Re: Planning Application 21/0194

Address: Daniels Farm Preston Road Alston Preston PR3 3BL.

Description: Change of use of one agricultural building to one dwelling under class Q (a) and (b).

Simon Hardie
Highways Development Control
Lancashire County Council

Indicative Block Plan
scale 1:500

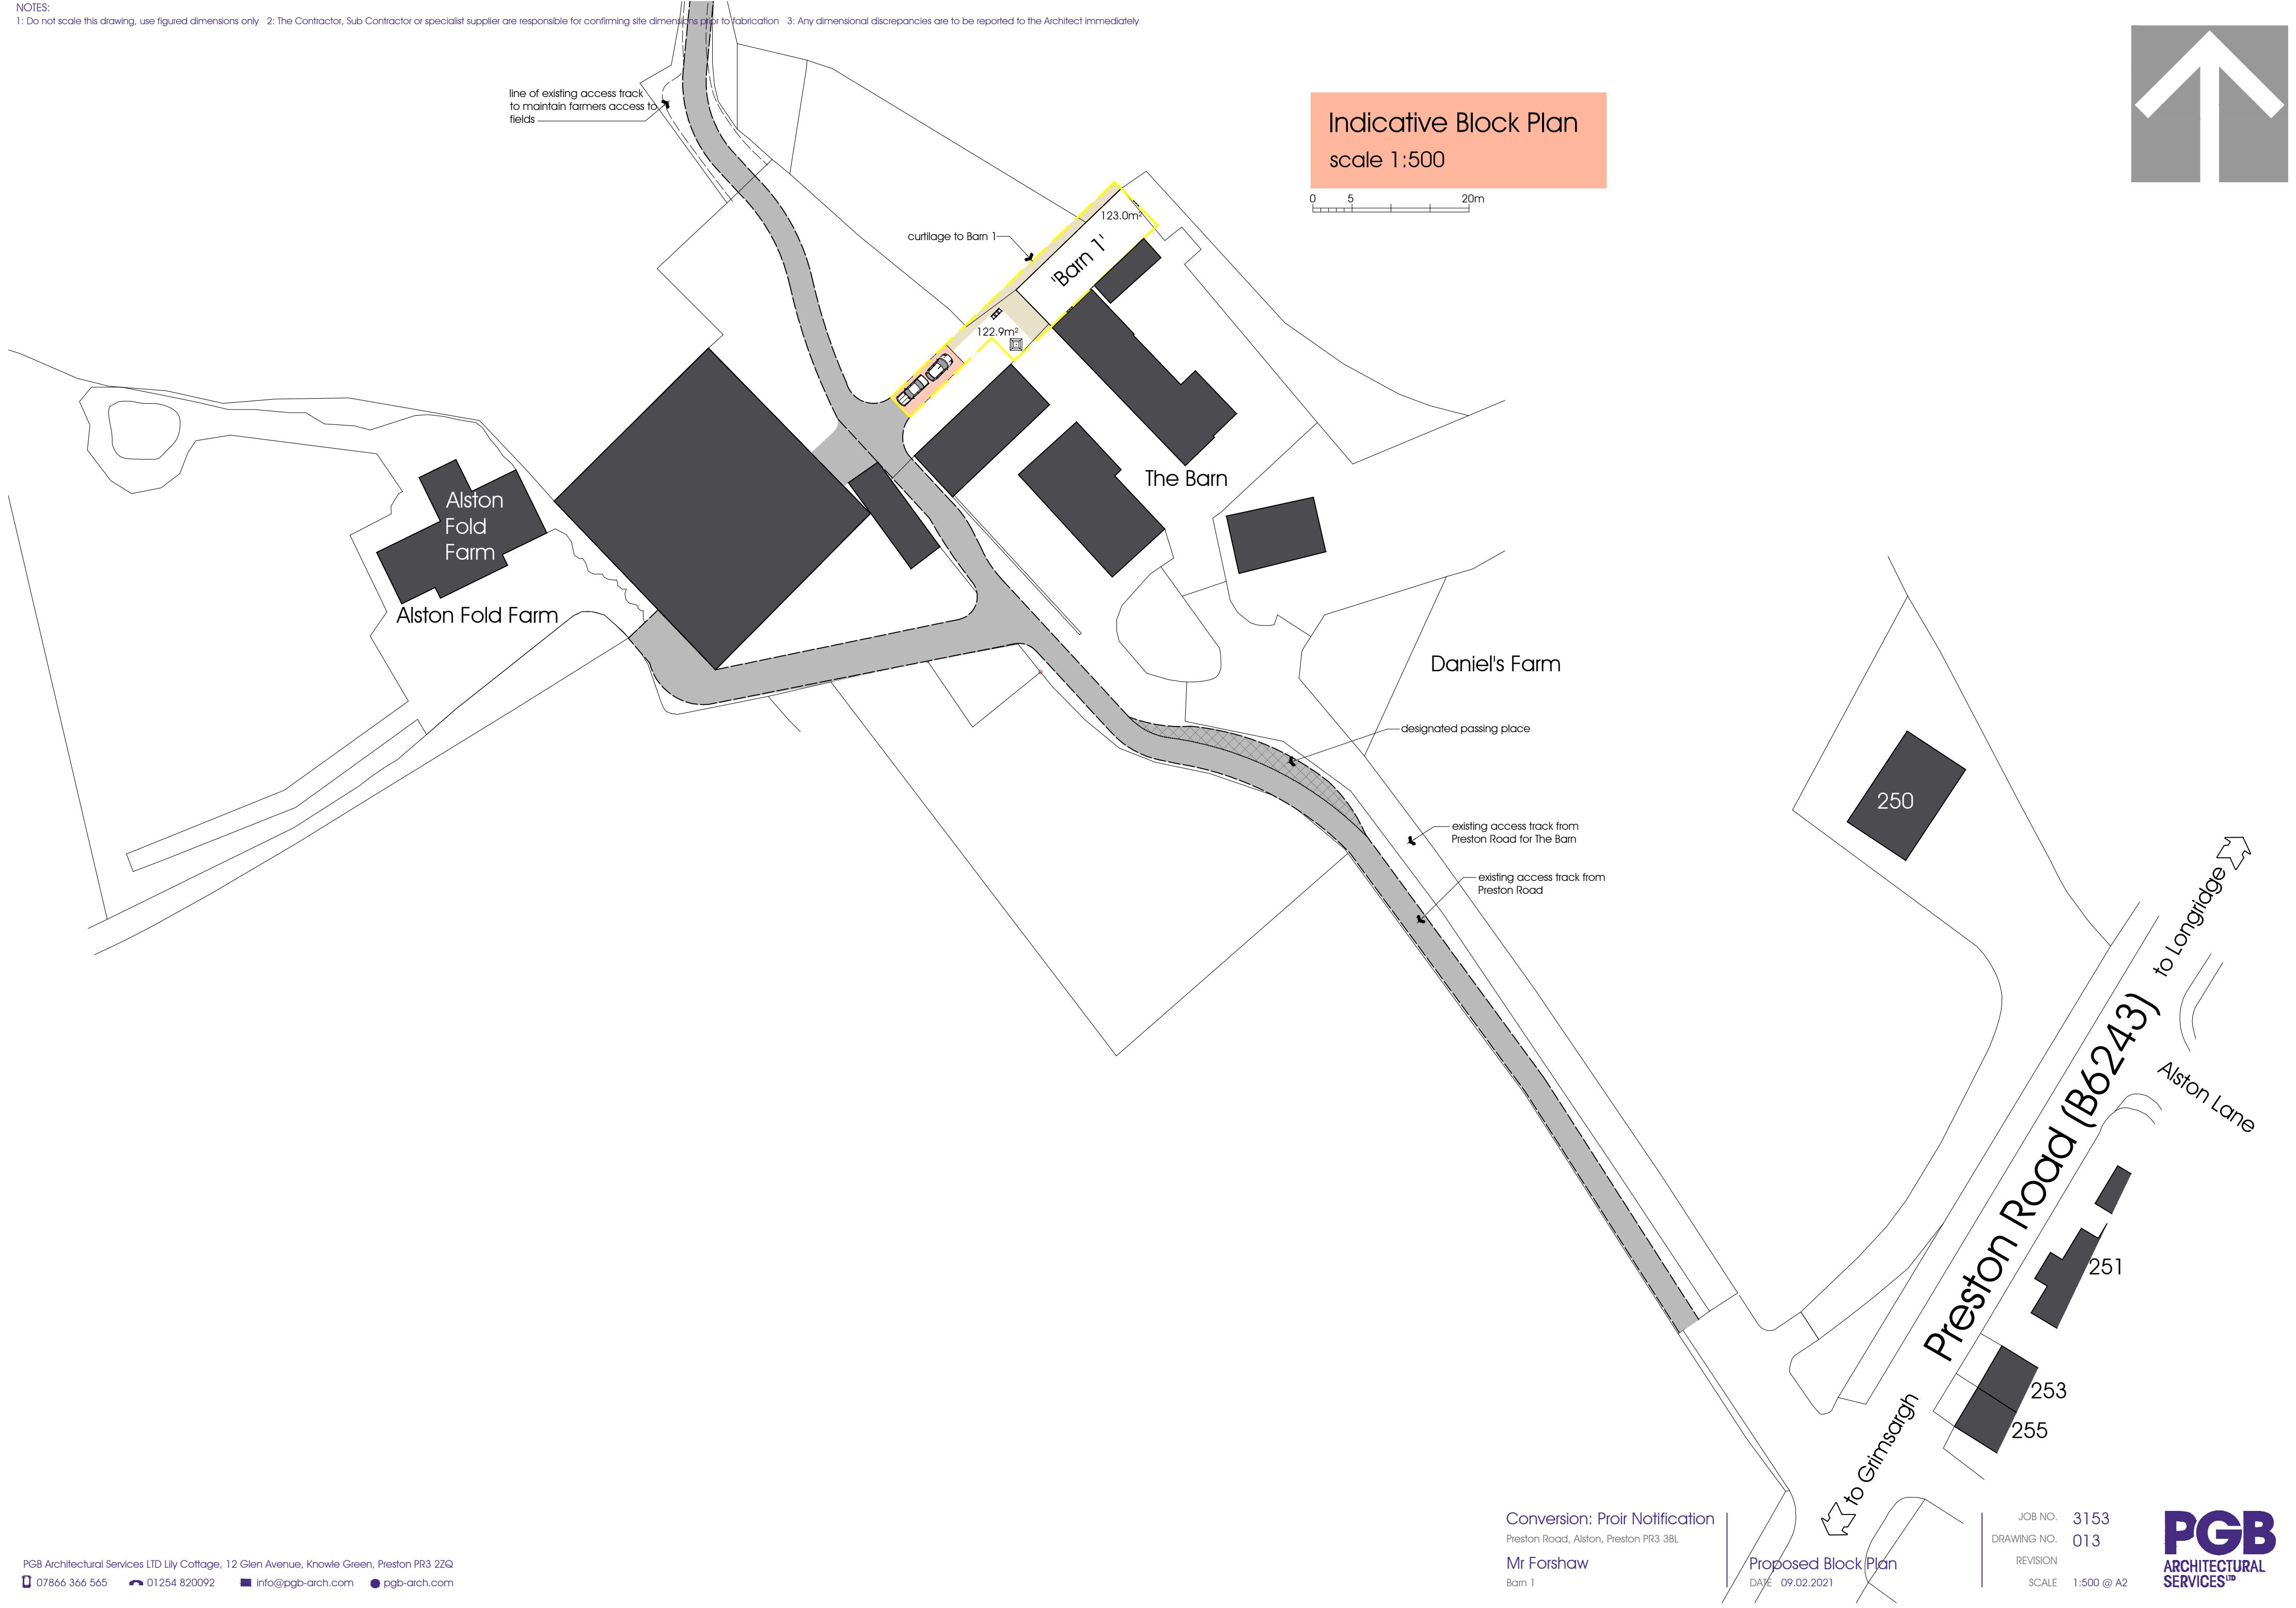
Due to the extensive nature of the application it is expected that a charging point for electric vehicles shall be included with-in the development to promote sustainable modes of transport. This shall be fitted in line with the DfT guidance regarding Electric Vehicle Charging in Residential and Non-residential buildings, which states :- charge points must have a minimum power rating output of 7kW, be fitted with a universal socket that can charge all types of electric vehicle.

All garage facilities on off street parking shall include provision of an electrical supply suitable for charging an electric motor vehicle.
